CITY OF ALBUQUERQUE

July 2nd, 2014

**Re: Chick-Fil-A on Eubank, Grading and Drainage Plan
Engineer's Stamp Date 6-27-14 (L21D045B)**

C-3.2

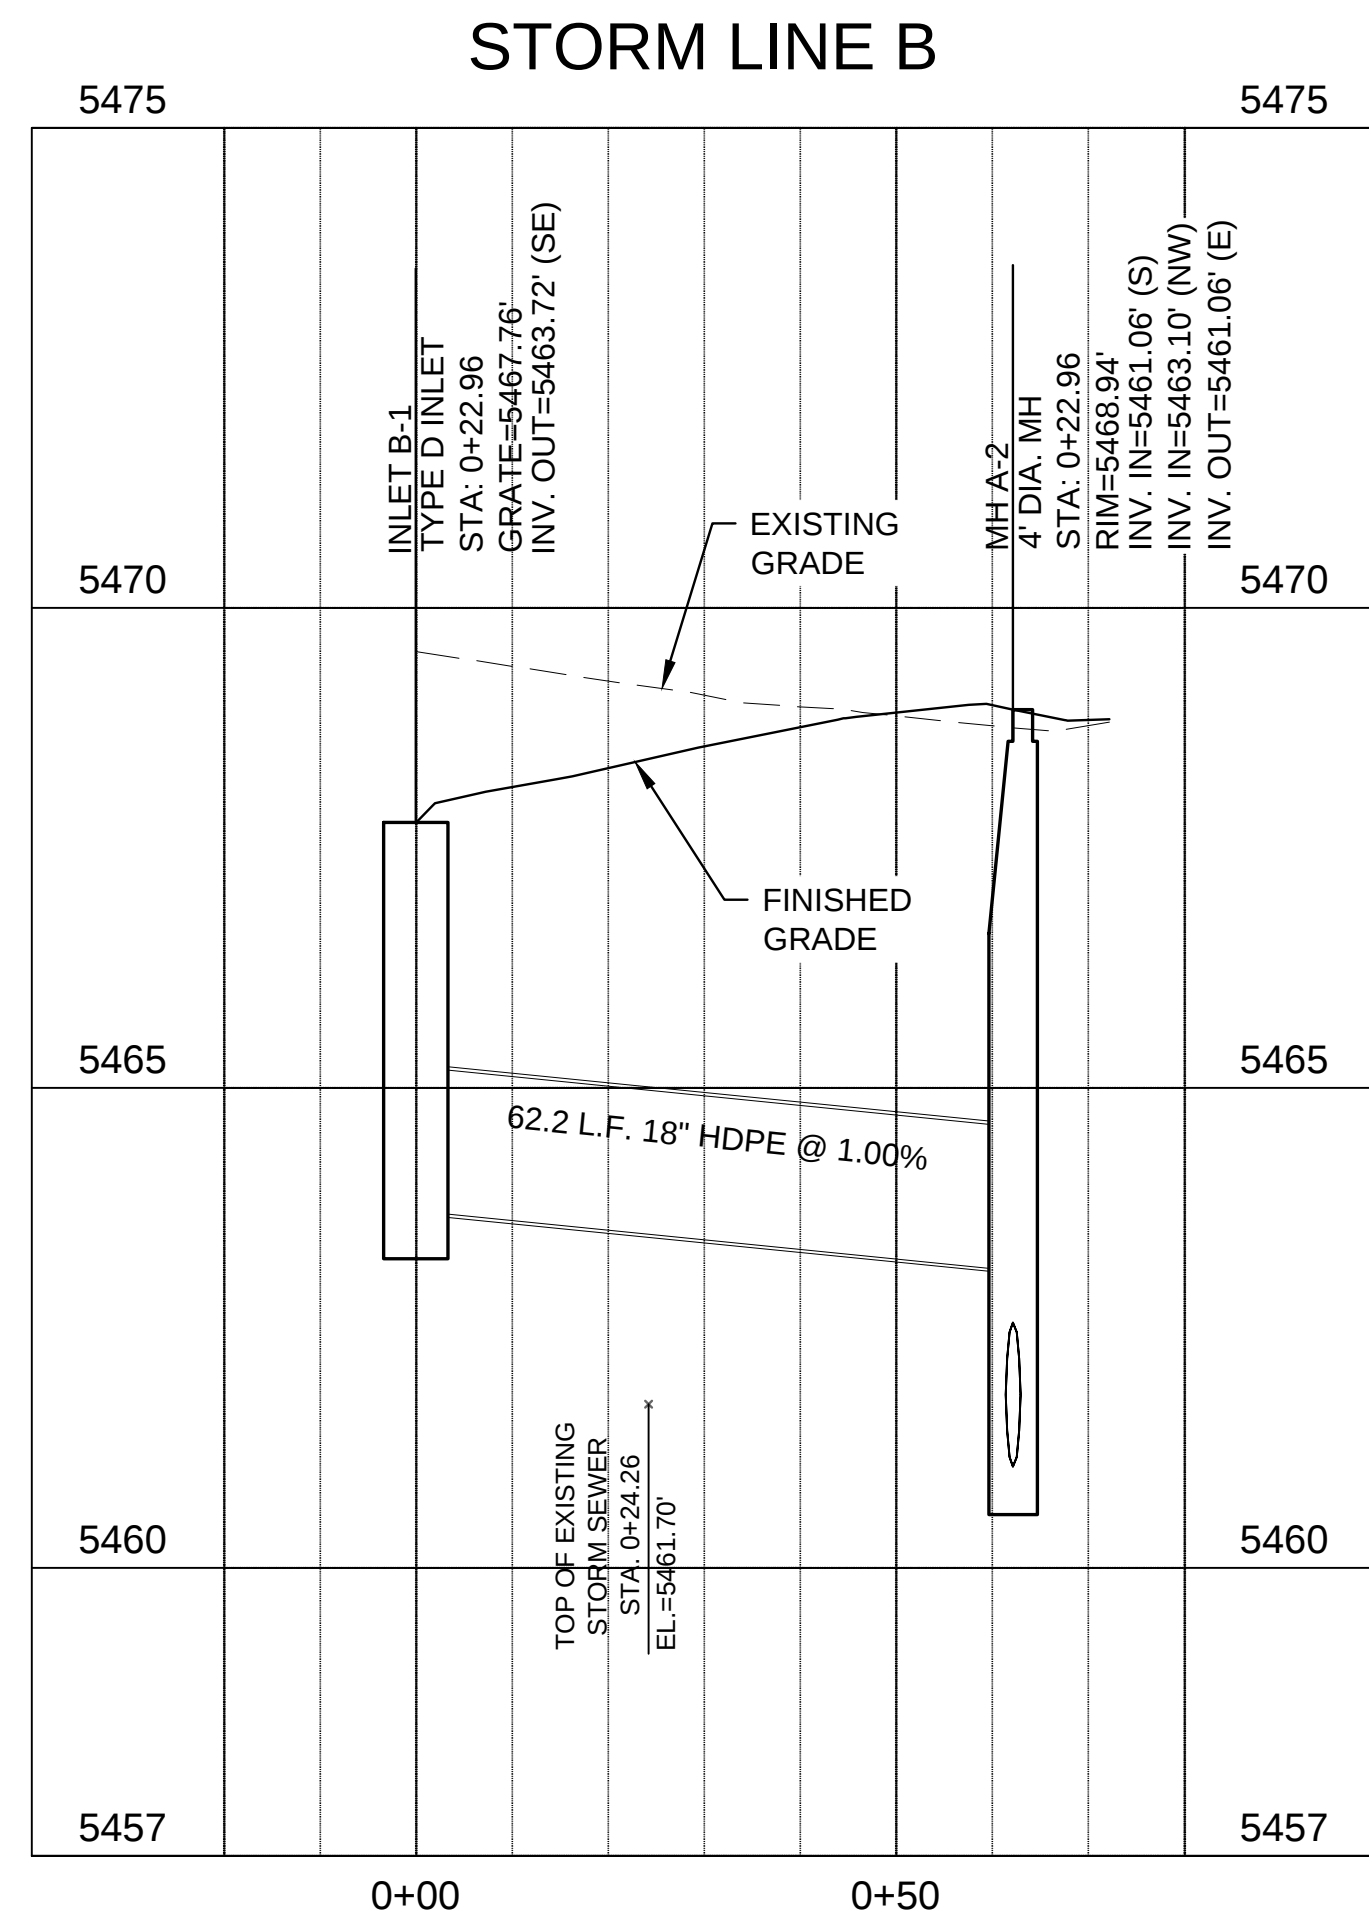
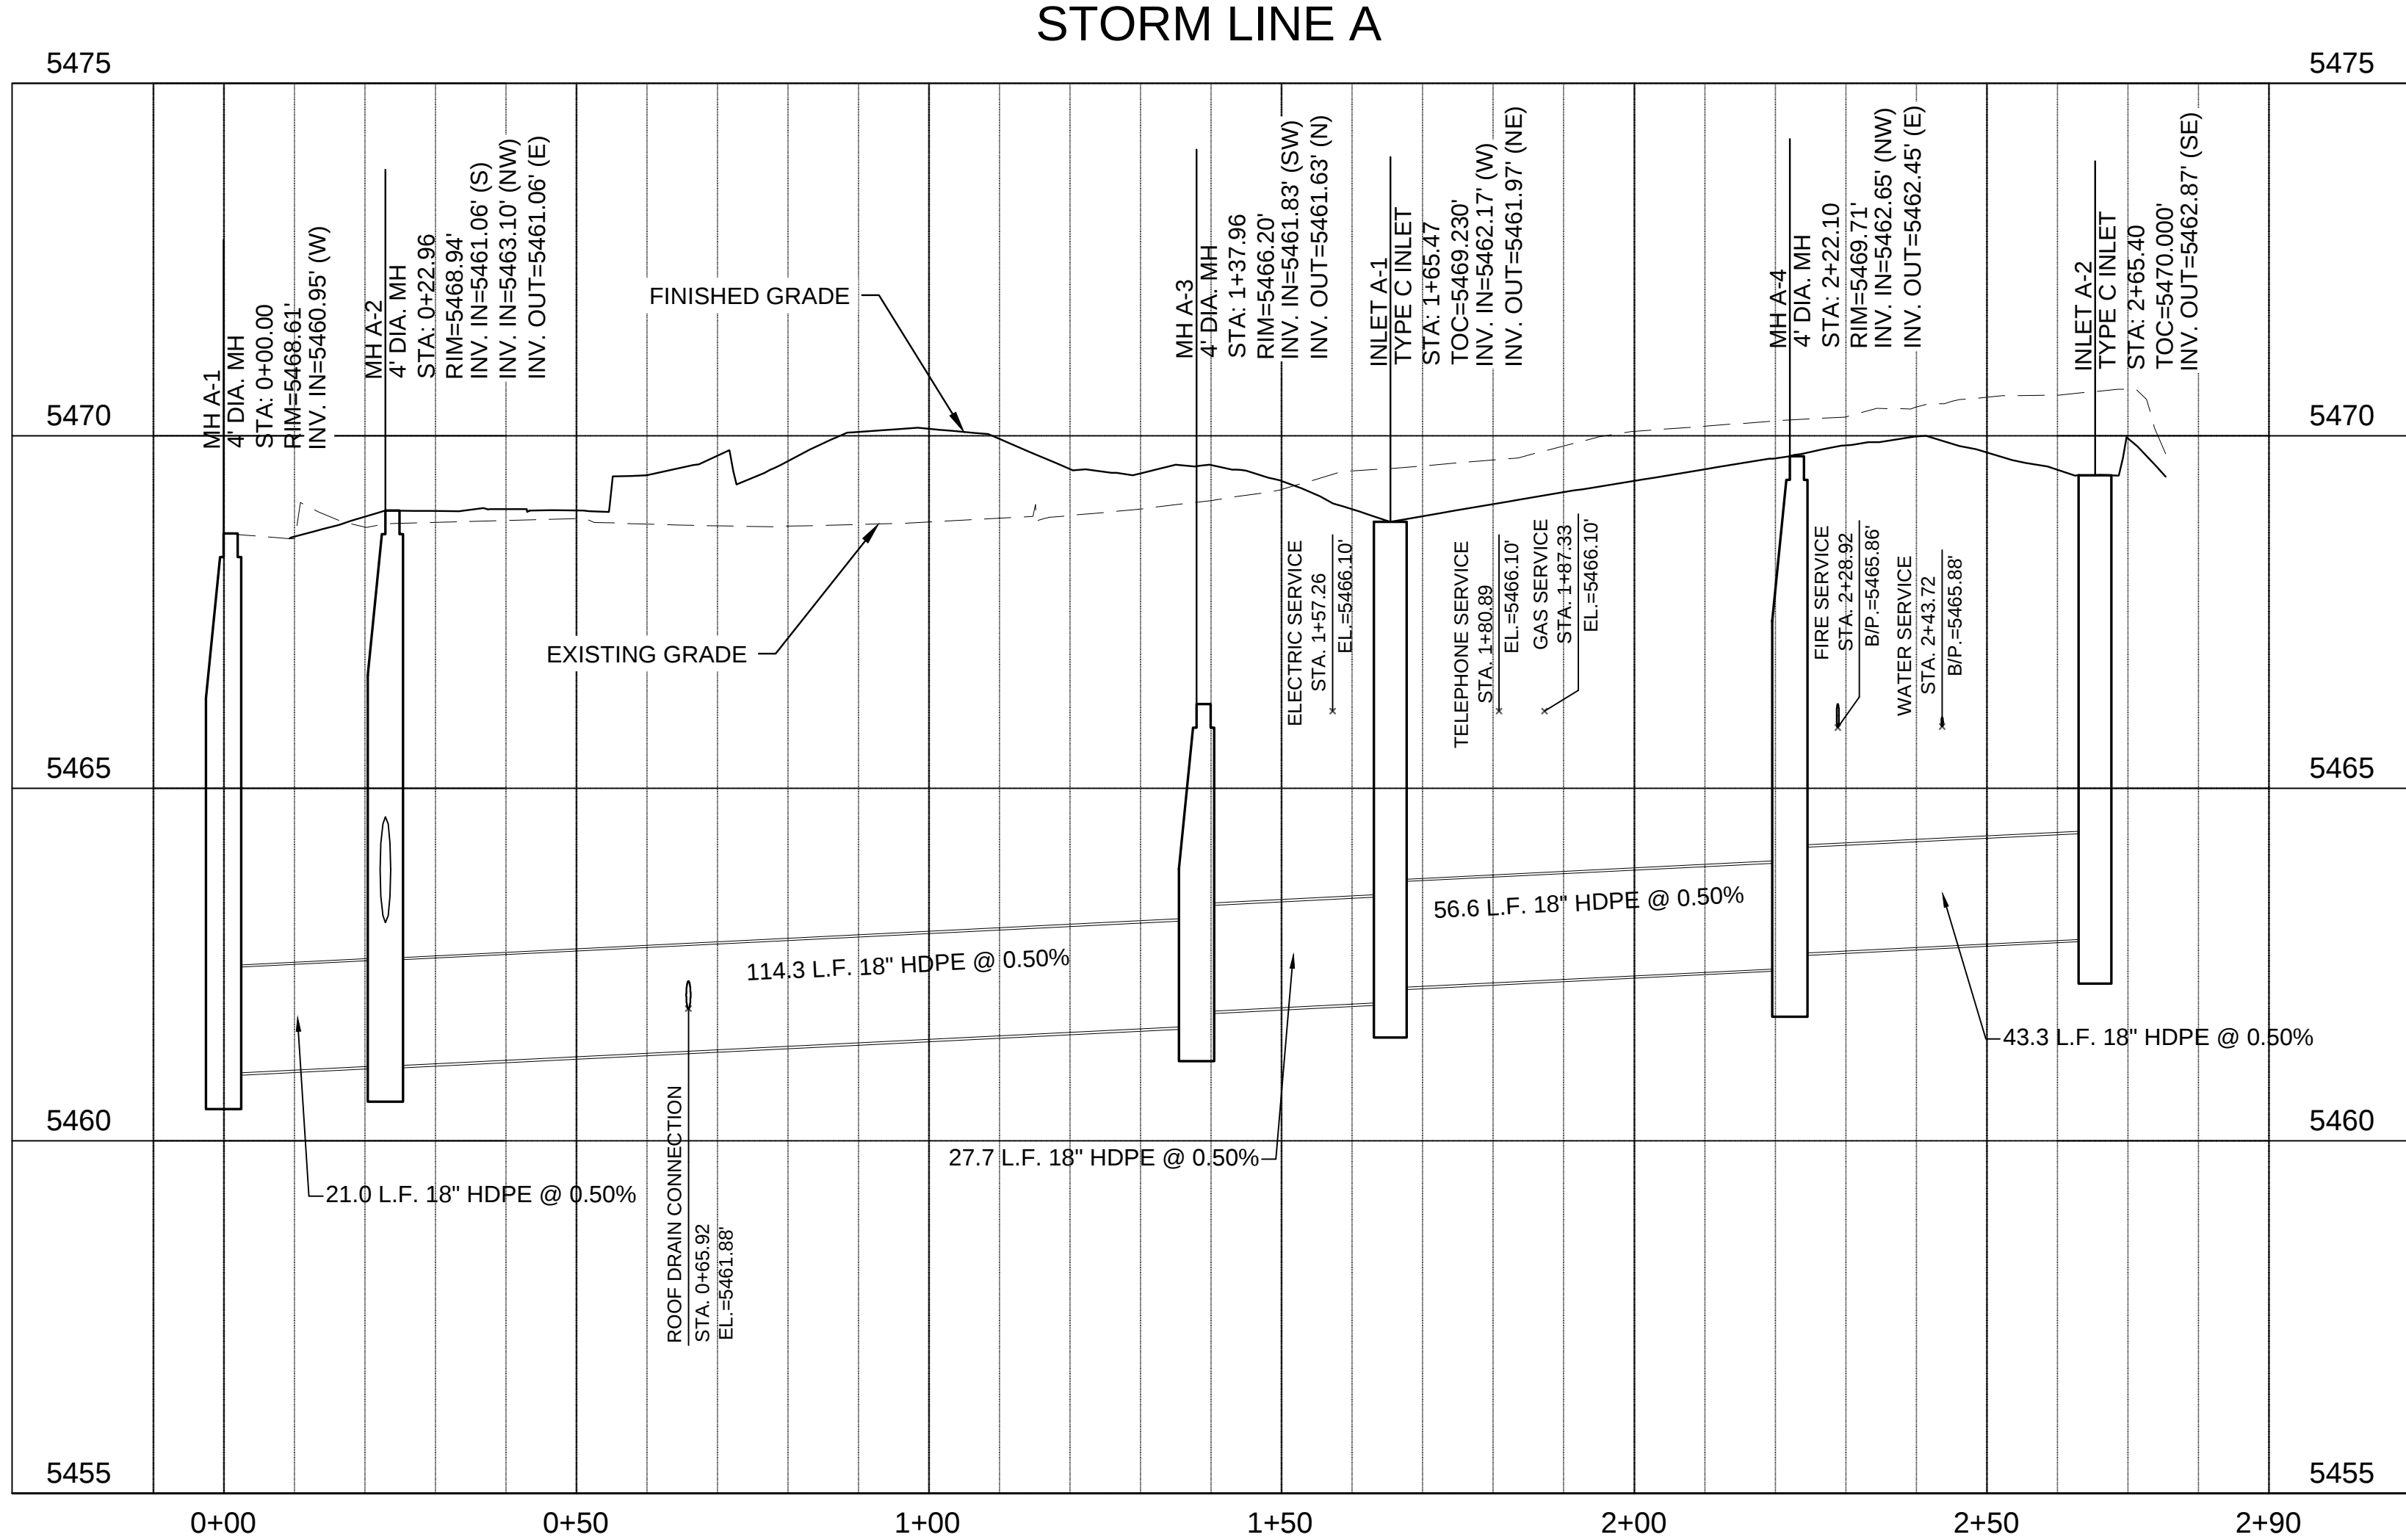
1. Include a Vicinity Map and either an image of the National Flood Insurance Map or a narrative on the flood zone status.
2. Is the proposed orifice plate required, since there is an orifice plate in the inlet that this system ties into?
3. Provide the direction of roof flows.
